City of Albuquerque Stormwater Construction Site Inspection Report

ESC File No.	Q16EA5000A	Project Name:	Kairos Power
NPDES Id. No.	NMR10033B/NMR1004XE	Location:	5201 Hawking Dr. SE
8/23/2022	Owner? - NMR10033B	NMR1004XE	
Operator	Kairos Power, LLC	Kairos Power, LLC	
Contact name & title	Lance Hagenbuch	Lara Gutierrez	
e-mail	hagenbuch@kairospower.com	gutierrez@kairospower.com	
Contact Phone #	510-230-3353	510-808-5265	
COA Inspector	Doug Hughes	Start/End Time:	11am
Construction Phase:	Stabilization		
Type of Inspection:	Regular	Storm Event	Past Storm Event >0.25"
		311/Complaint	Follow Up
Weather at time of inspection?	clear	Temperature: ~	80
Estimated date of last storm 0.25" or greater	8/21/2022

ESCP 1

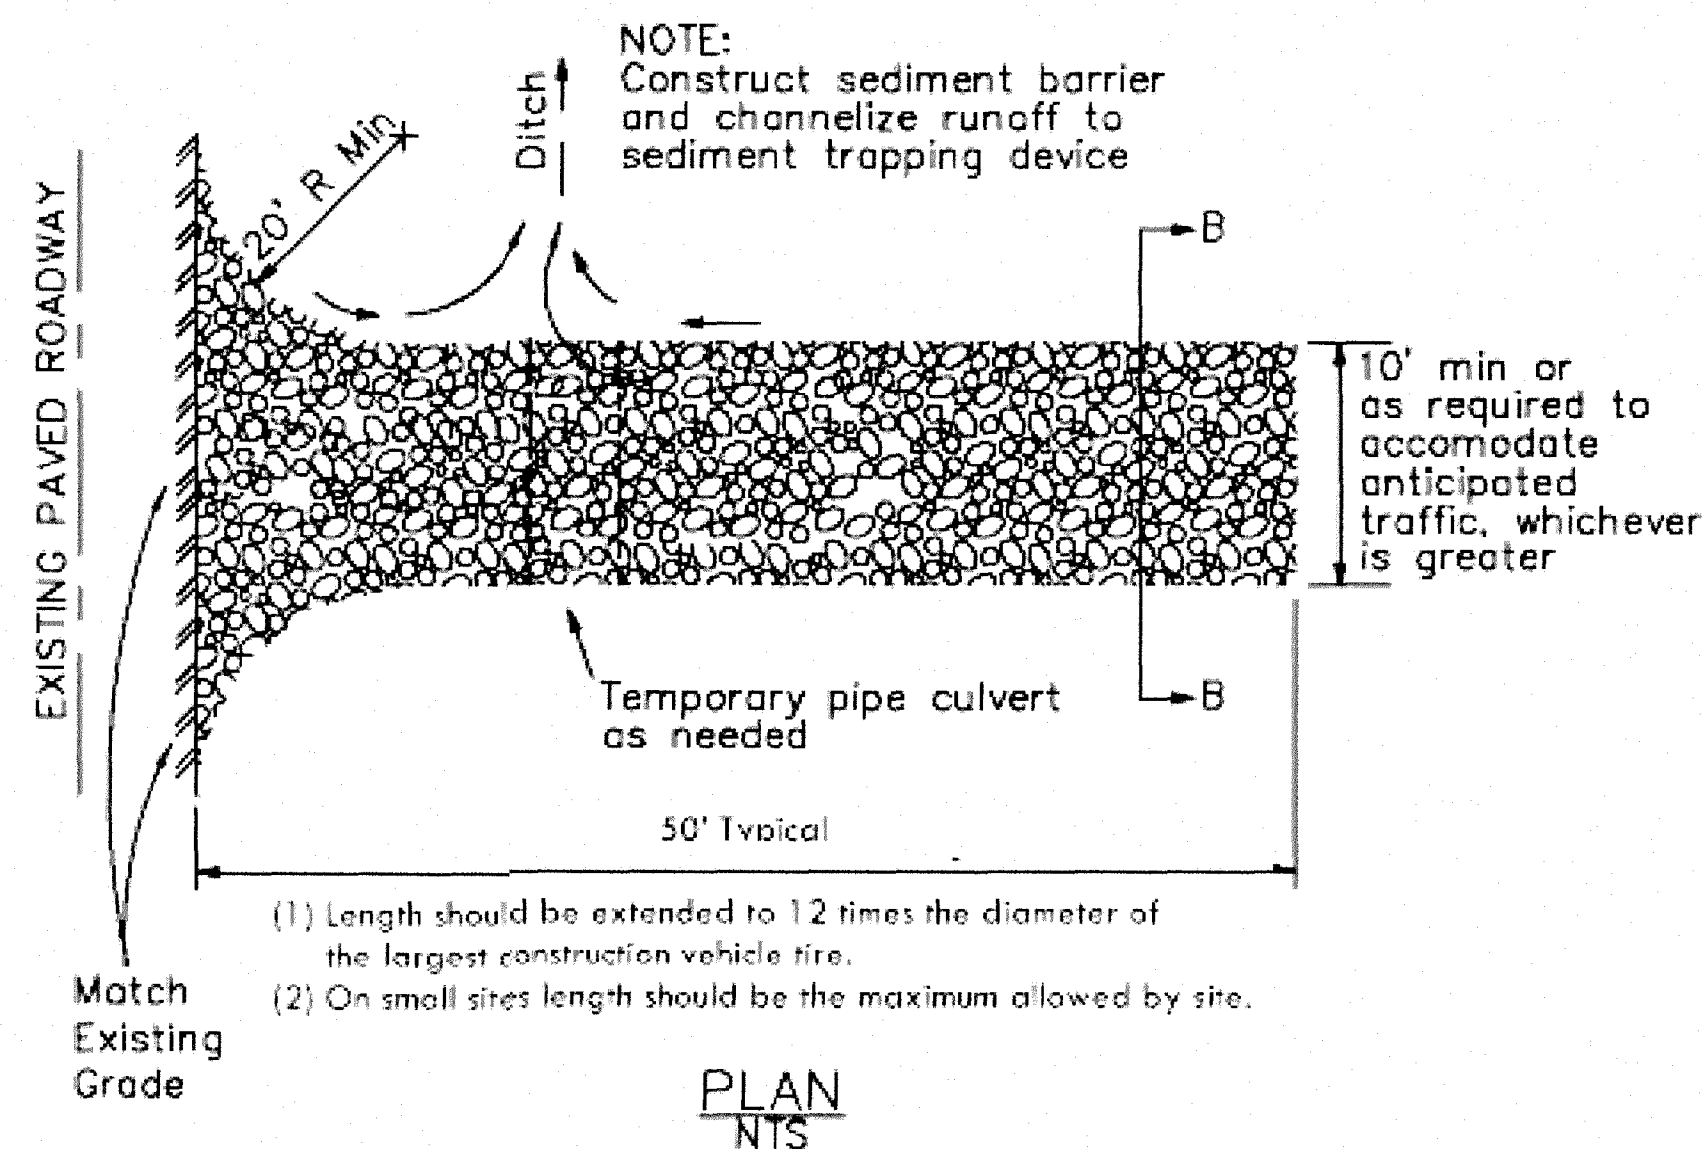
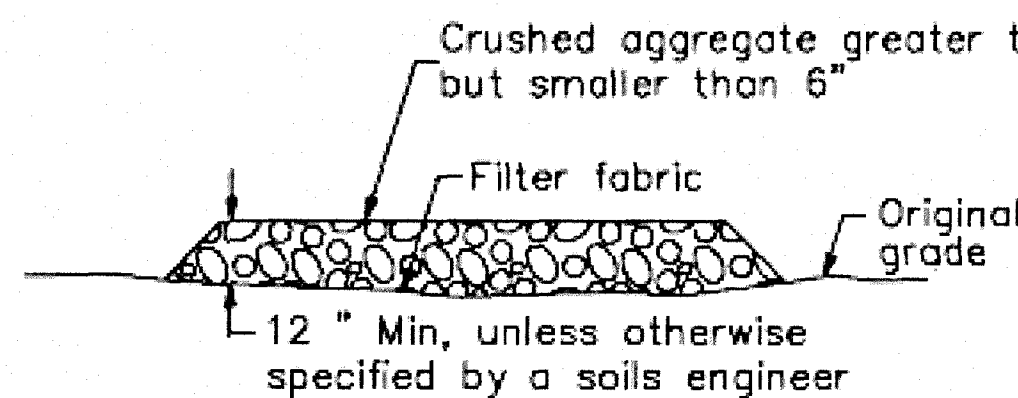
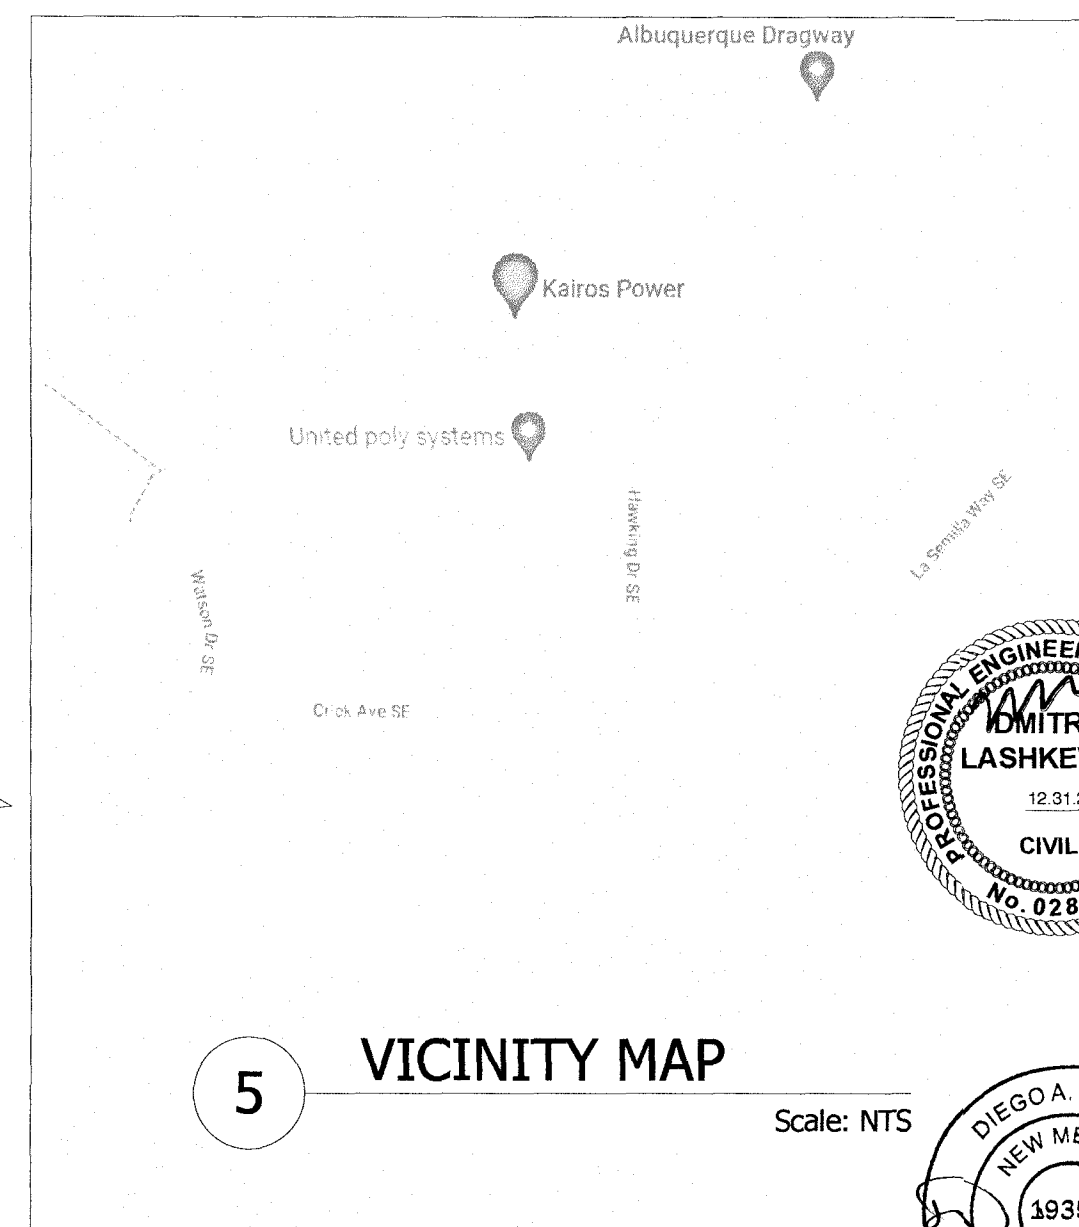
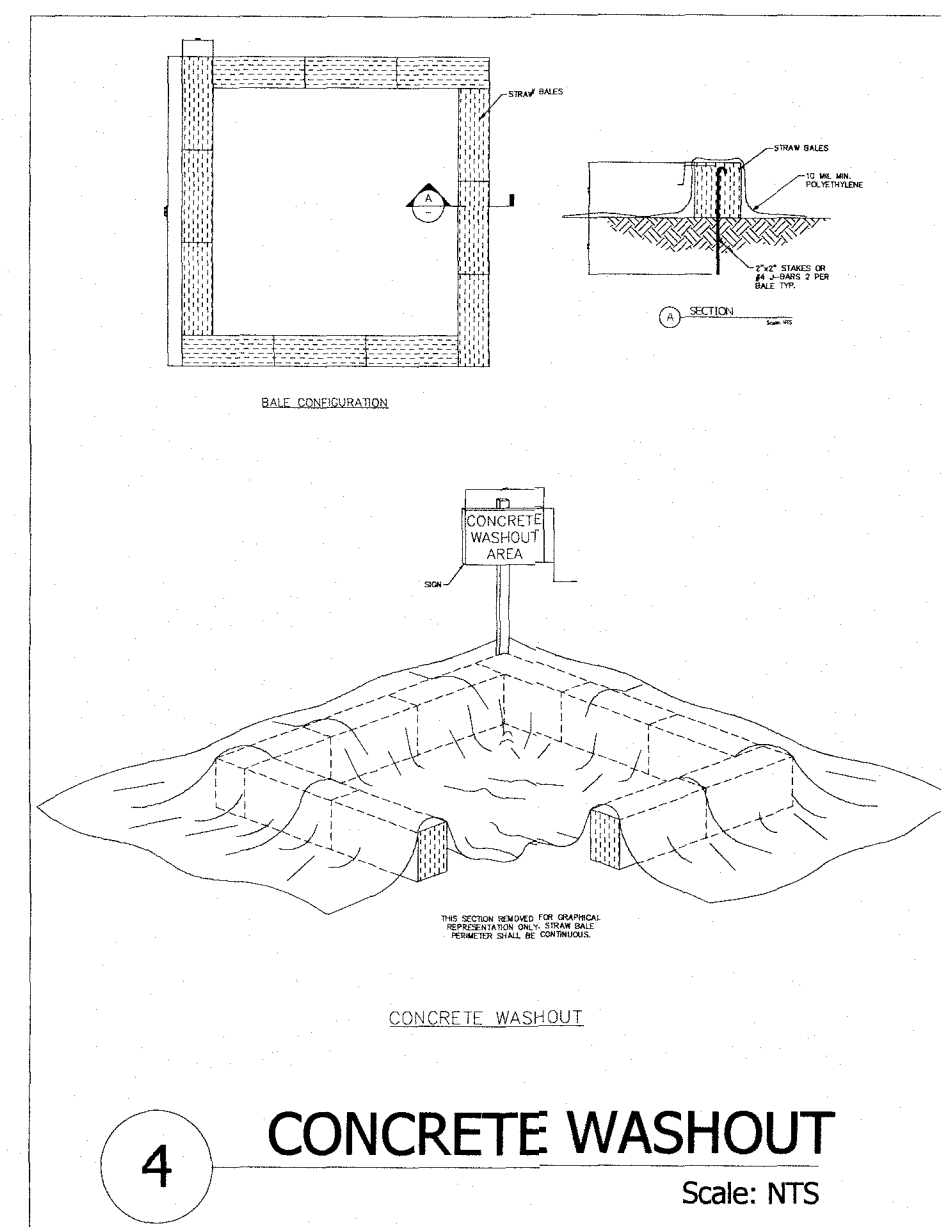
Item Number	Deficiency/ Corrective Action		
1	Posting of permit coverage was missing. Post signage of NOI permit coverage in a location clearly visible to the public CGP1.5.		
2	The up-to-date SWPPP was not available onsite. The SWPPP must include current self-inspection reports and an accurate SWPPP map showing current BMPs and current area of disturbance per CGP 7.2.1 and 7.2.4.		
3	Permit coverage lapsed from termination of NMR10033B on 2/18/2022 to issuance of new coverage NMR1004XE effective on 7/22/2022. Termination was certified by Estefanita Maestas of stormwatersolutionsllc4@gmail.com. Provide explanation for lapse in coverage, missing inspections, and delay in stabilization.		
4	Inactive areas must be stabilized within 14 days per CGP2.2.14.
